**Re: Paradise RV Park (aka Birdie RV Park) Phase 2 at 221 Leonidas Ln NW  
Erosion and Sediment Control Plan – K08E003 – (SWQ-2025-00046)  
Engineer's Stamp Date: 8/27/25**

Based on the information in your submittal received on 8/27/25, the ESC Plan and Notice of Intent (NOI) can not be approved until the following comments are addressed.

TRACT 5
CONCEPTUAL GRADING AND DRAINAGE PLAN

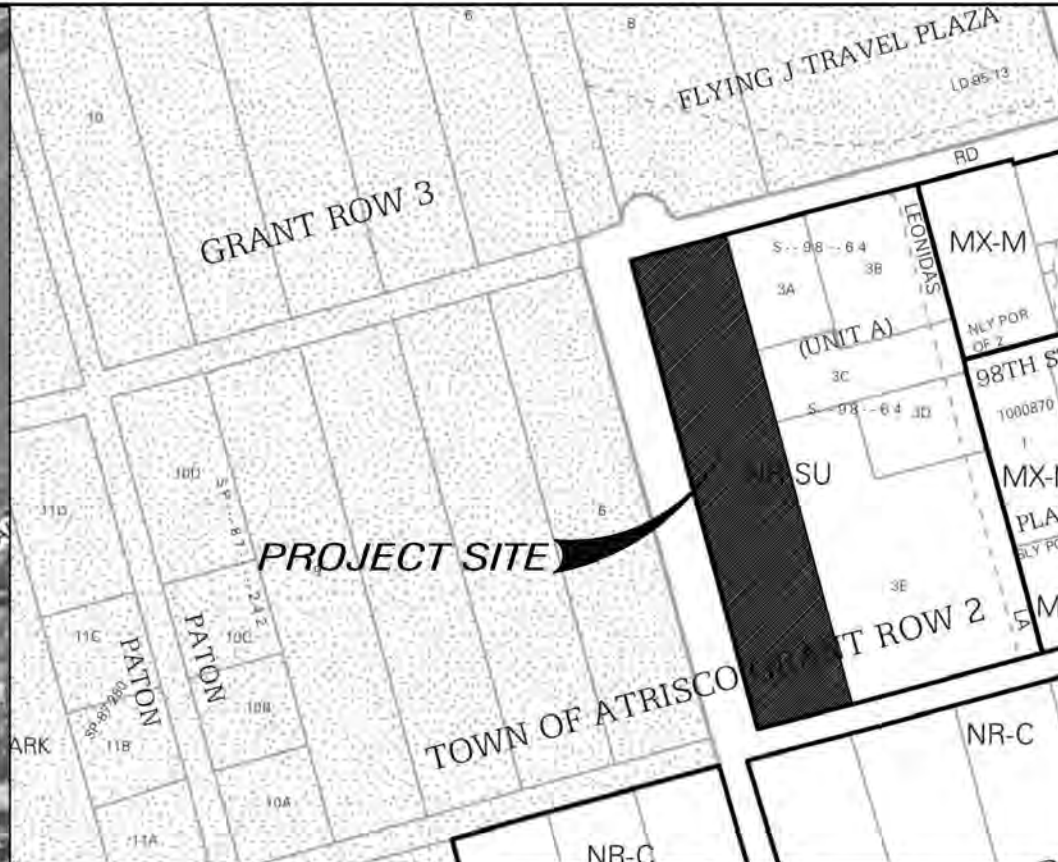
2. Stormwater controls are absent on the Esc Plan for the 4-acre commercial section of Phase 2. The ESC Plan must include an onsite sediment trap (ST) and diversion (DV) to direct onsite drainage into the ST. A construction exit (CE) is also necessary.

3. The ESC Plan stormwater controls are shown on a Conceptual G&D Plan approved by City Hydrology on 9/11/23 for DFT action, not for construction. According to Google Earth, the Phase 1 pond had been filled by the Phase 2 grading by 8/19/2024; however, Phase 2 wasn't approved for Grading until 4/29/25. The existing and proposed grades and drainage features on the ESC Plan must match those shown on the G&D Plan, most recently approved by the Hydrology Section.
